M42 Junction 6 Development Consent Order

8.20(a) Statement of Common Ground with Birmingham Airport Ltd

STATEMENT OF COMMON GROUND
Birmingham Airport Ltd

Version	Date	Status of Version
2	15 July 2019	Version 2 Updated Draft for Deadline 3

WORK No. 21  
SEGREGATED LEFT TURN LANE FROM MAINLINE LINK TO A45 WESTBOUND  
ALIGNMENT STRING NAME : M4AS

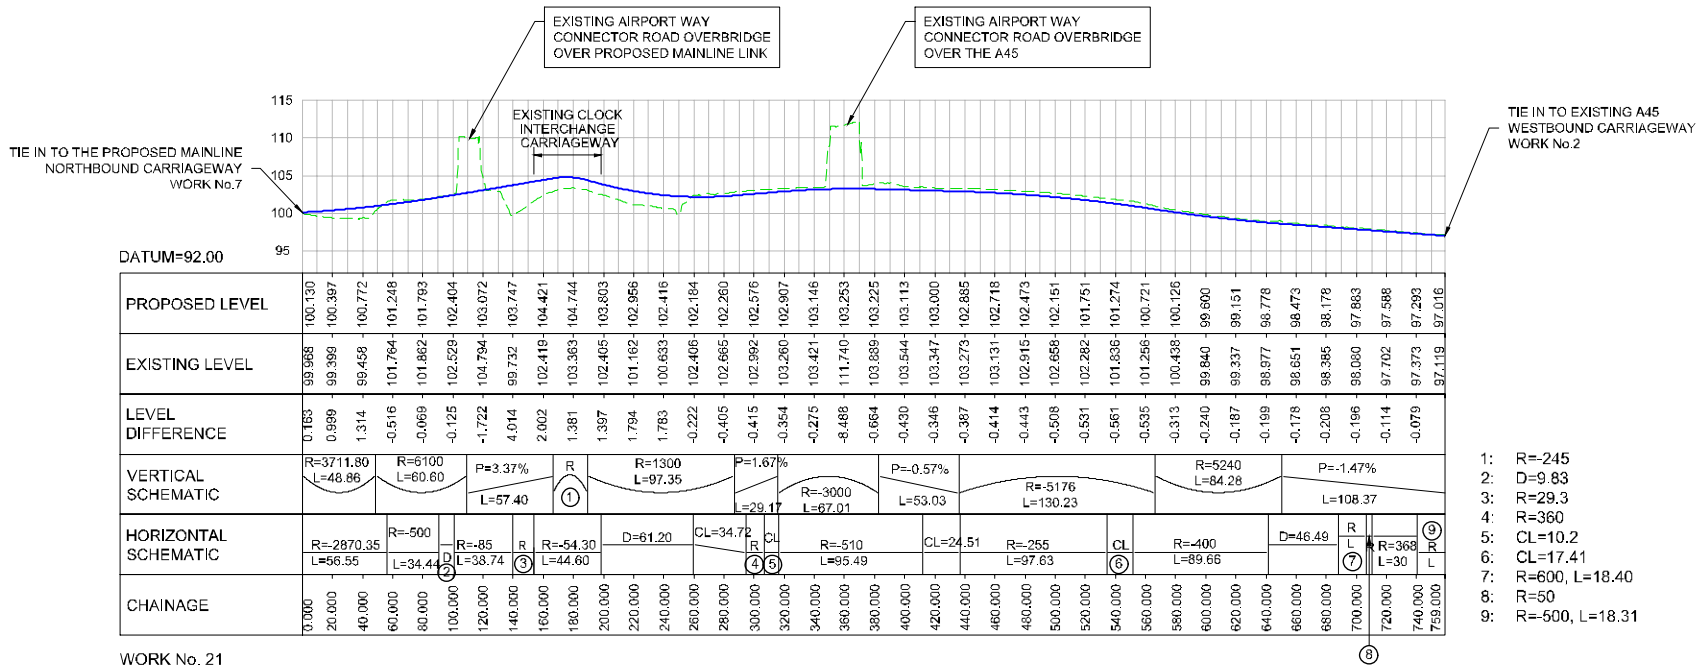
Sub-topic	Birmingham Airport Comment	Highways England Response/Actions	Status/Agreement
Design			
Clock Interchange – Segregated left Turn Lane	The Airport previously had concerns that the location of the segregated left turn lane may preclude the provision of two merging lanes onto the A45 westbound, as part of any future works required to be implemented by the airport to facilitate growing passenger numbers. Additional detail has been provided in the current application where the proposed scheme design now indicates that two lanes are able to exit the Clock Interchange circulatory carriageway onto the A45 westbound, in addition to the proposed segregated left turn. However, concerns previously raised relating to potential high growth at the airport necessitating the reconstruction of Clock Interchange and in turn requiring the segregated left turn to be relocated remain valid. In addition, the plans showing the	The Applicant notes Birmingham Airport's concerns and provided additional information in its response in the letter dated 18.6.19 and will continue to provide further detail.	Under Discussion

Sub-topic	Birmingham Airport Comment	Highways England Response/Actions	Status/Agreement
	proposed scheme also highlight a very short length of queue storage between the stop line at Clock Interchange and the diverge point of the segregated left turn, which is dictated by the existing bridge width. This short length of queue storage suggests that blocking back of the segregated left turn lane may occur during busy periods when queues develop back from the stop line. Whilst the LinSig modelling exercise undertaken as part of the Transport Assessment did not highlight significant blocking back from the junction, the high volumes of traffic which are likely to use the segregated left turn lane mean this is potentially a cause for concern.		
	We also have concerns that the proposals may struggle to accommodate future traffic growth associated with large scale developments such as the UK Central Hub Area, NEC or JLR, all of which are likely to result in increased volumes of traffic passing through Clock Interchange during peak periods. As such we strongly recommend that any changes which would increase the queue storage area, or move the segregated left turn diverge further back from the roundabout stop line are	The Applicant notes Birmingham Airport's concerns and provided additional information in its response in the letter dated 18.6.19 and will continue to provide further detail.	Under Discussion

**PLAN OF A45 PEDESTRIAN OVERBRIDGE**  
Scale 1:500

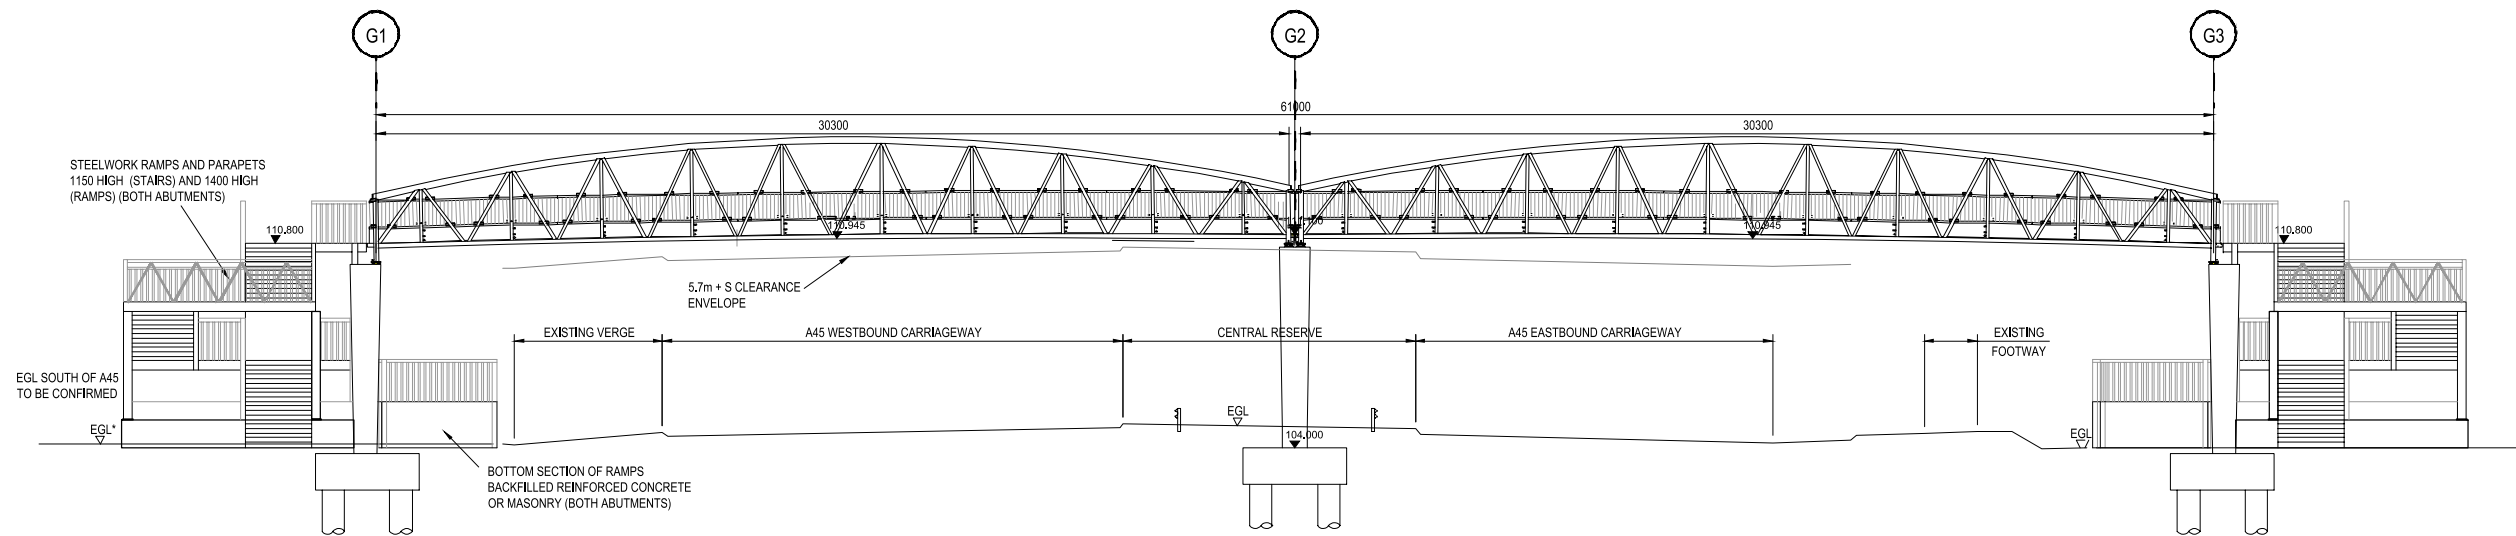
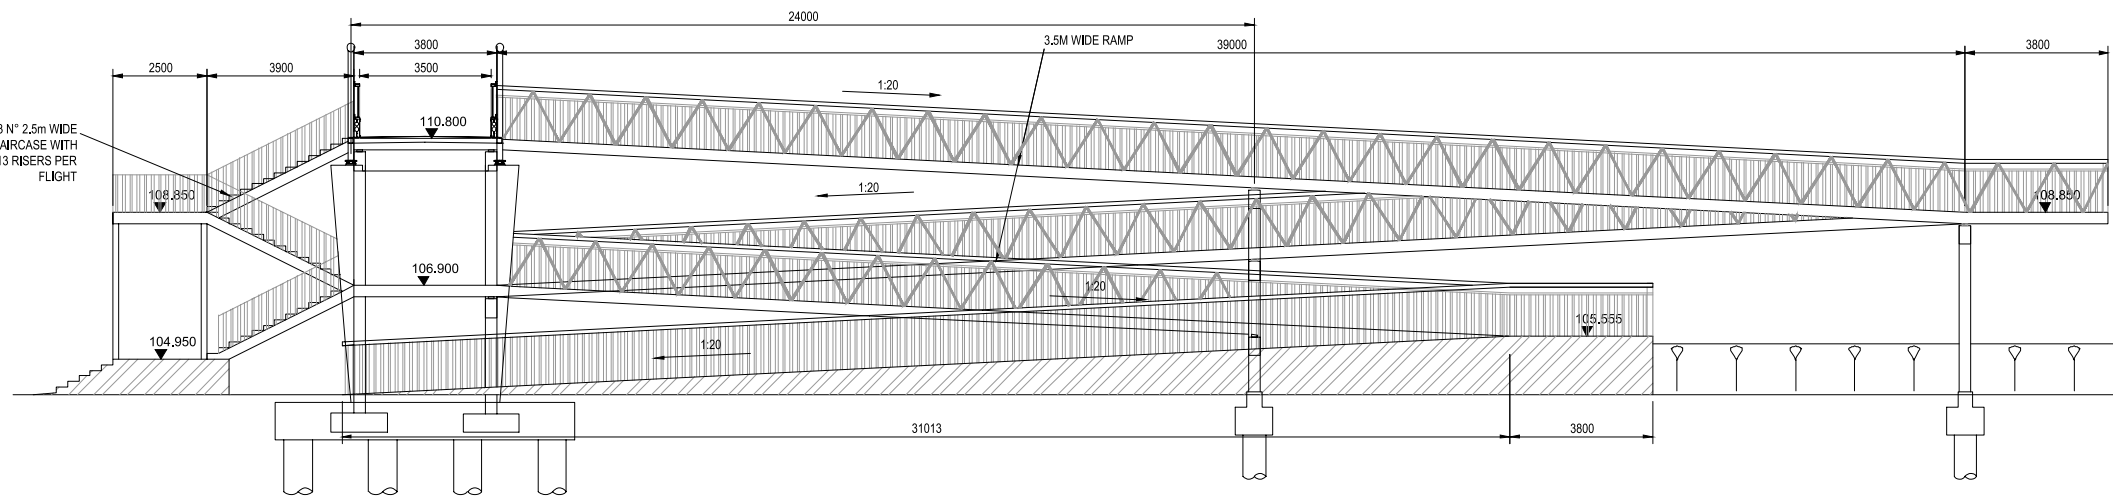
Sub-topic	Birmingham Airport Comment	Highways England Response/Actions	Status/Agreement
Cyclist Provision	A pedestrian footbridge is proposed to cross the A45 adjacent to the West Coast Mainline. However, cyclists should also be able to ride across this bridge without the need to dismount.	Highways England can confirm that the proposed A45 Pedestrian Overbridge has been designed as a 3.5m wide pedestrian cycleway in accordance with the Design Manual for Roads and Bridges (DMRB) BD29/17, Design Criteria for Footbridges. Subsequently cyclists wishing to cross the A45 shall not need to dismount.	Agreed
Land and Property			
	Highways England have previously been made aware that Birmingham Airport Limited (BAL) has easements in its favour over a large part of the land included in the Order limits for the Development Consent Order to the South of the A45 Coventry Road. These are to ensure we can reduce the height of trees to below the level of the Obstacle Limitation Surface for the Airport runway in the interests of aviation safety. No provisions are included in the application to preserve and maintain these easement rights following acquisition of land for the Scheme. In addition, BAL has issued a draft Order under Section 44 of the Civil Aviation Act 1982, the Birmingham Airport (Rights over Land) Order 2014 seeking to acquire such rights over other areas of land.	Where Highways England is seeking to use land temporarily, Highways England confirms that the existing easement shall be retained. Where Highways England is seeking to acquire land permanently, Highways England confirmed that the existing easement shall be retained under Article 28(7) of the DCO. Further discussion between both parties are required in order to determine protocols for co-ordination regarding land access and traffic management.	Under discussion
